Arun Parks and Landscapes response

Response to Planning Application

Application ref: WA/75/25/AOO

Description: Application to approve First Schedule Clause 4 (Public Open Space Land and Play Areas) in the Section 106 dated 28.07.22 (as amended) in relation to planning permission WA/68/20/OUT.

scheme: Tye Lane
Walberton, Arundel
client: Barratt Homes
drawing: Play Area Proposal
date: April 2022
scale: 1:200@A1
drawing no: BDWS23688 20 Sheet 1
drawn: LS checked: DKM

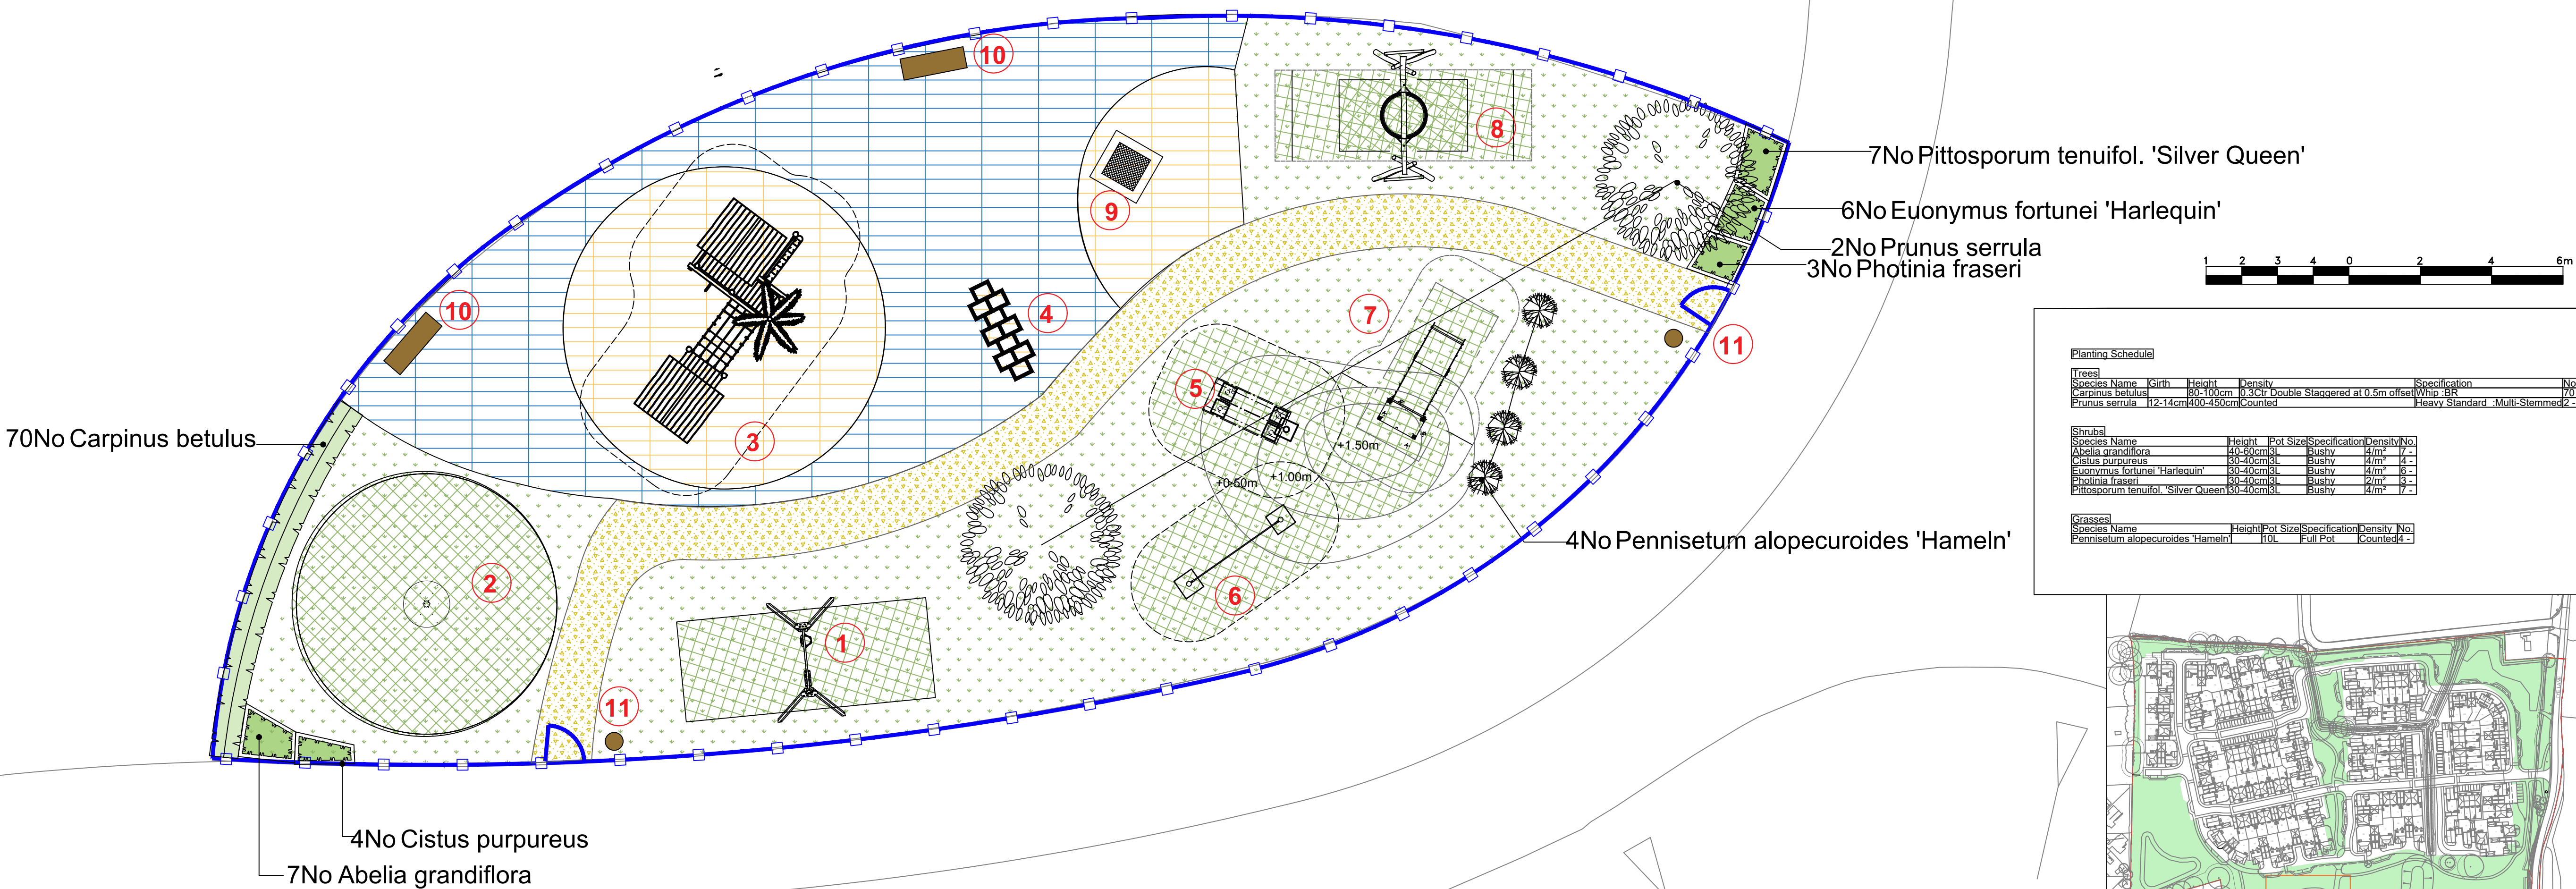
I would also flag reference is made to the LEAP having been approved under Play under BDWS23668 21 – however I don't recall having sight of this previously and can see no detail plan submitted under WA/27/24/NMA to which has been referenced as approved? Please provide clarification when the Play LEAP dwg was submitted ie under which application as confirmation that this detail was in fact submitted and approved.

drawing no: BDWS23688 22 Sheet 1
scale: 1:50@A1
drawn: RH checked: DKM

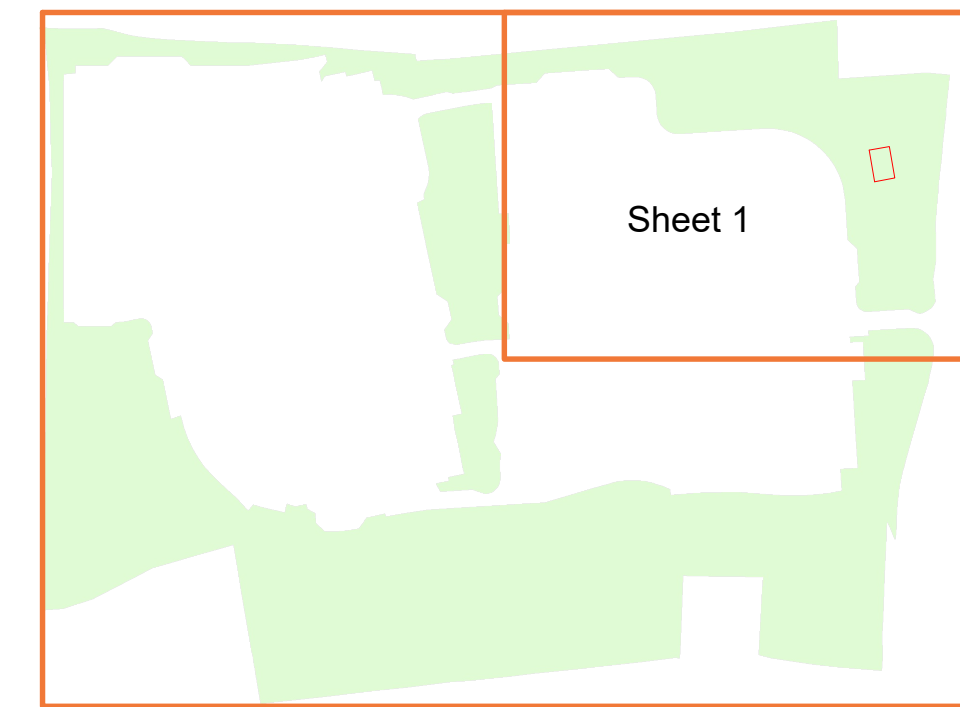
The NMA application WA/25/24/NMA also showed within several plans and overall plan BDWS 23668 20 Sheet 53no LAPs and 1no LEAP whereas the detail submitted under this WA/75/25/AOO application only contains inadequate information for 1no LAP. The LAP detail shown in the LAP POS proposal BDWS23688 22 Sheet 1 proposes very basic LAP provision for the 1no LAP shown. 3no LAPs are required for this development therefore I would raise objection to the information submitted as unsuitable.

To summarise LAP provision detail is inadequate and needs to detail the 3no LAPs approved under the outline application. LEAP provision needs to confirm under which application the LEAP was submitted and approved?
